# Rezoning Transportation Analysis

Petition Number: #2022-082

Date	Description
11-28-22	First Review (TM)
12-22-22	Second Review (DR)

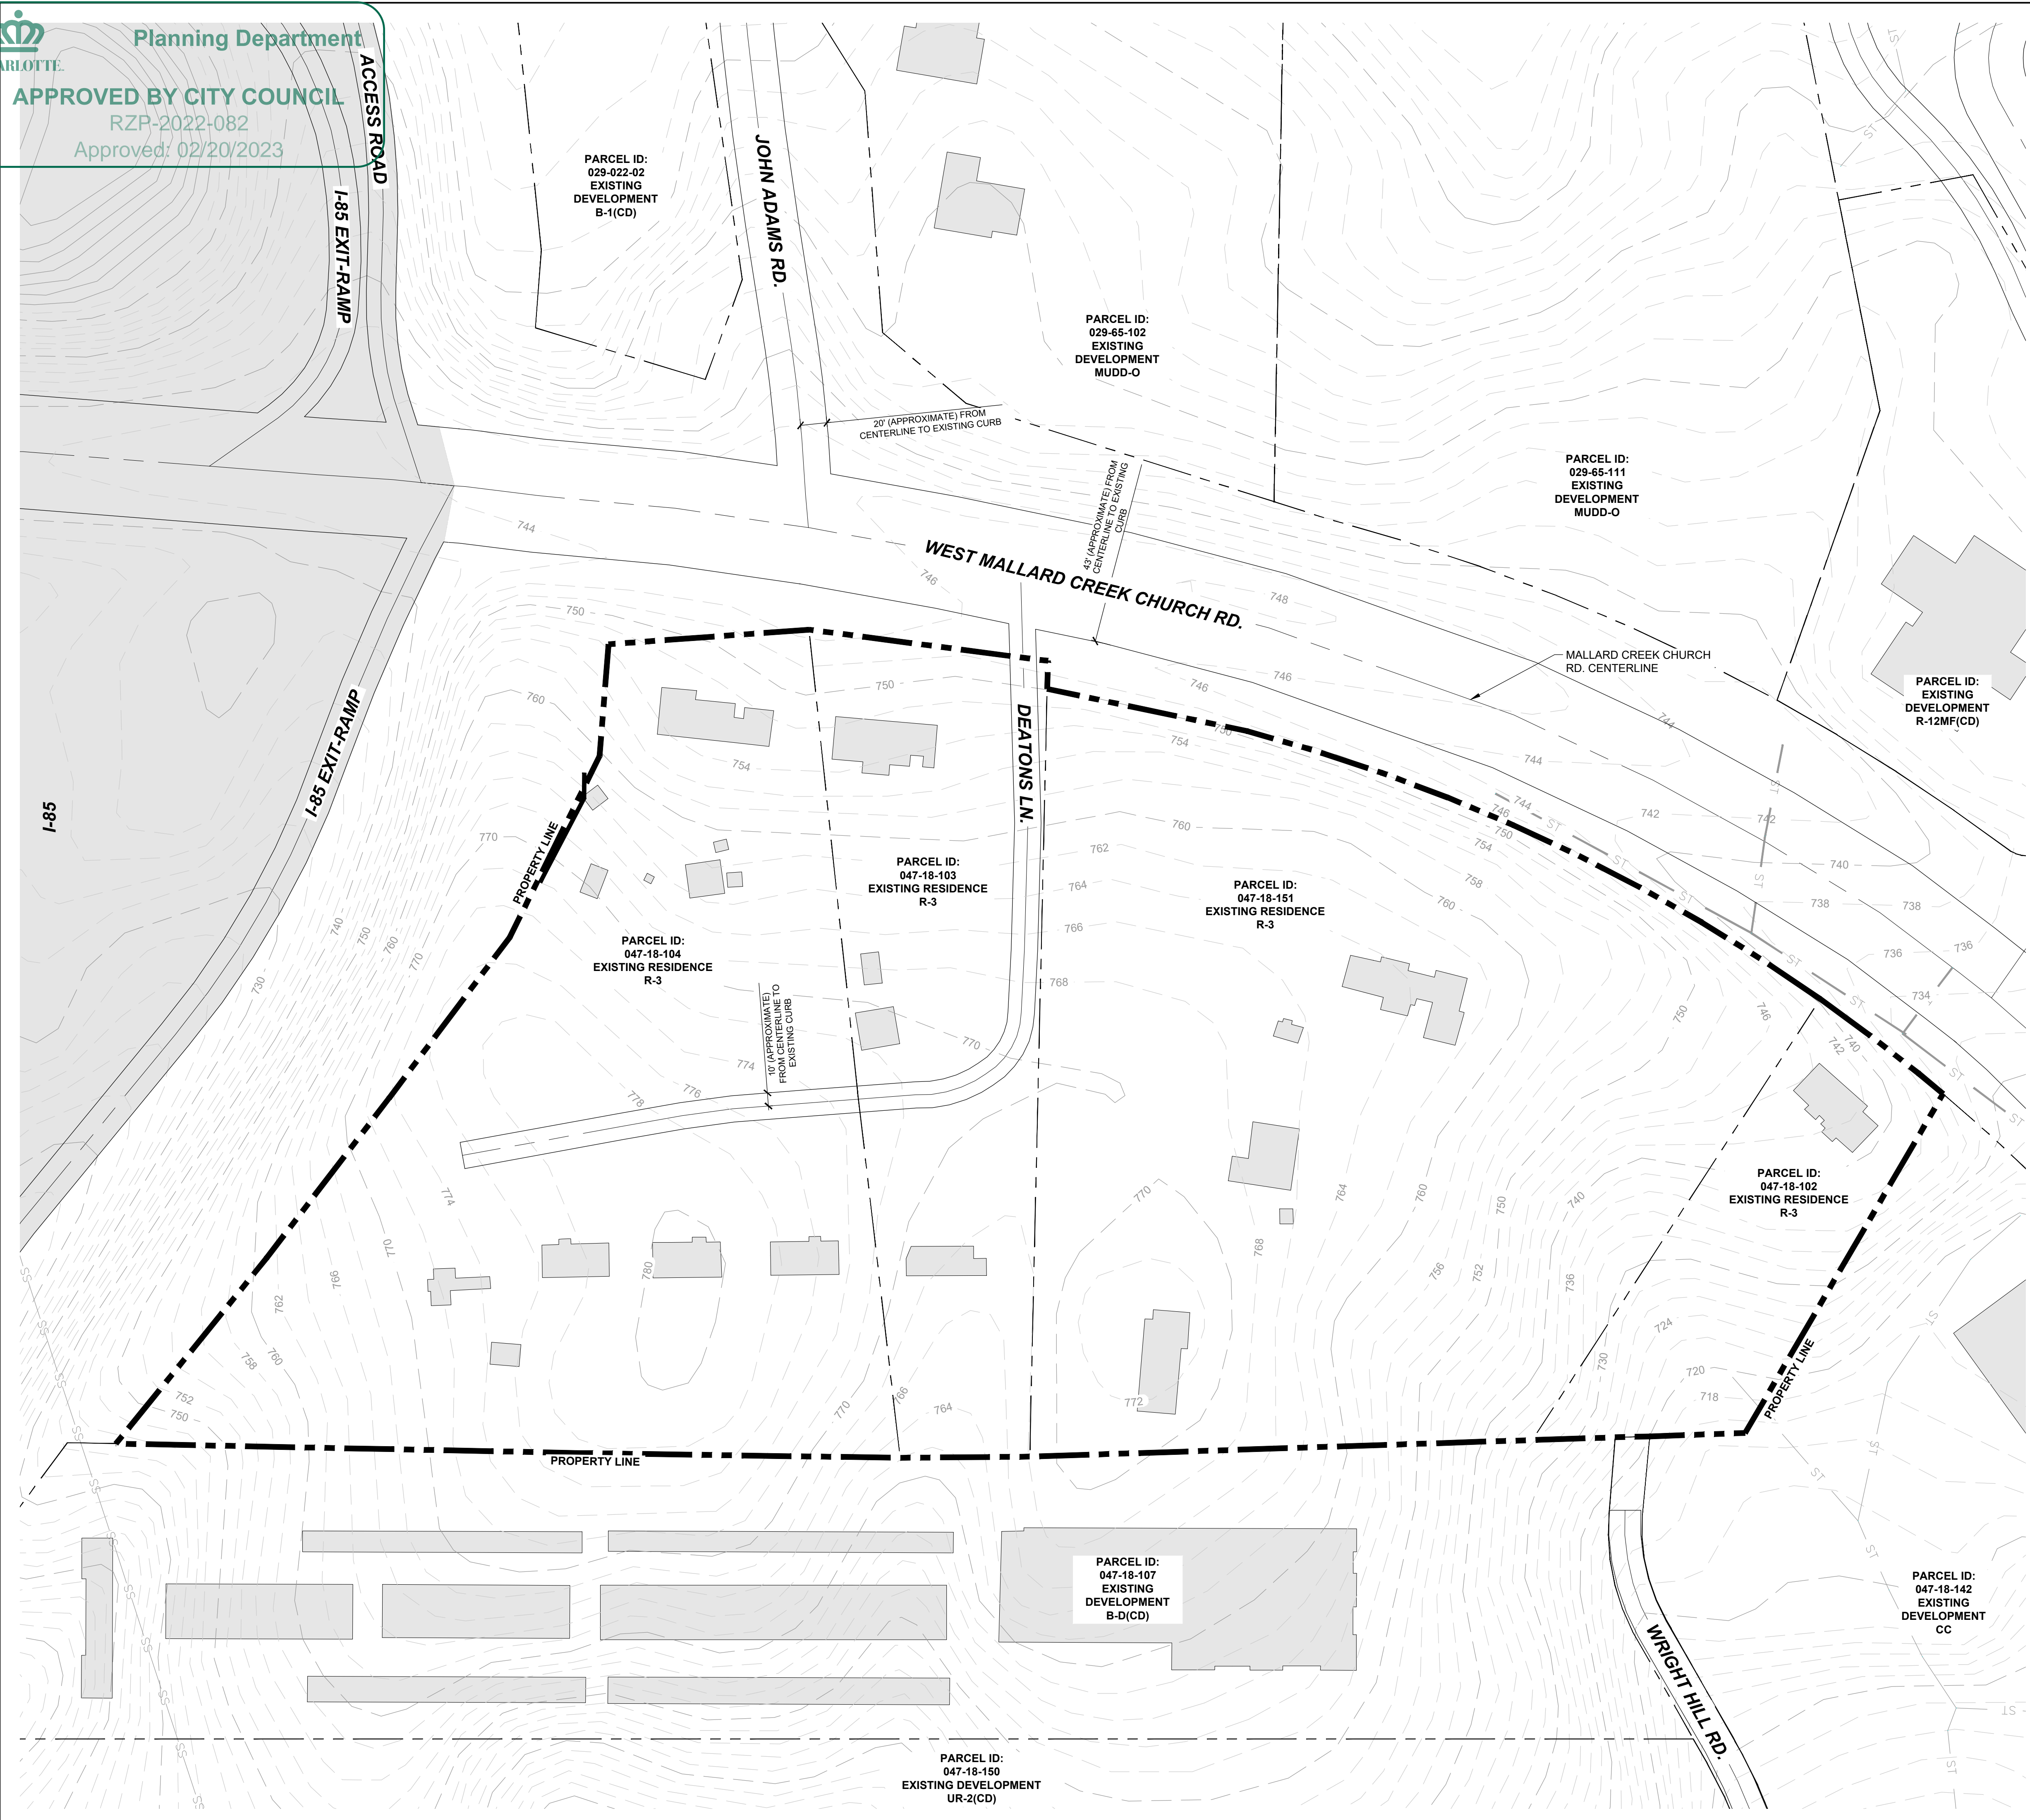
**Outstanding comment from 11-28-22:** Label and dimension the curb and gutter from the centerline for each road on the site plan.

**Clarifying comment 12-22-22:** Label and dimension proposed curb & gutter, planting strip, and multi-use path from centerline of West Mallard Creek Church Road.

7. **Outstanding comment from 11-28-22:** Site plan and conditional note(s) revisions are needed to remove the proposed left over from the site plan. Per NCDOT comments, this movement will not be permissible.
8. Site plan and conditional note(s) revisions are needed to commit to aligning proposed Wright Hill Roadway extension to become a 4<sup>th</sup> leg at the intersection of Mallard creek and Mallard Glen Drive.

**Clarifying comment 12-22-22:** Add conditional note that Wright Hill Road will be extended and aligned to create a 4<sup>th</sup> leg at Mallard Creek and Mallard Glen Drive if necessary easements can be acquired and the street extension can be properly engineered. Proposed right-in/right-out access will be allowed if realignment of Wright Hill Road is not feasible in consultation with NCDOT and CDOT.
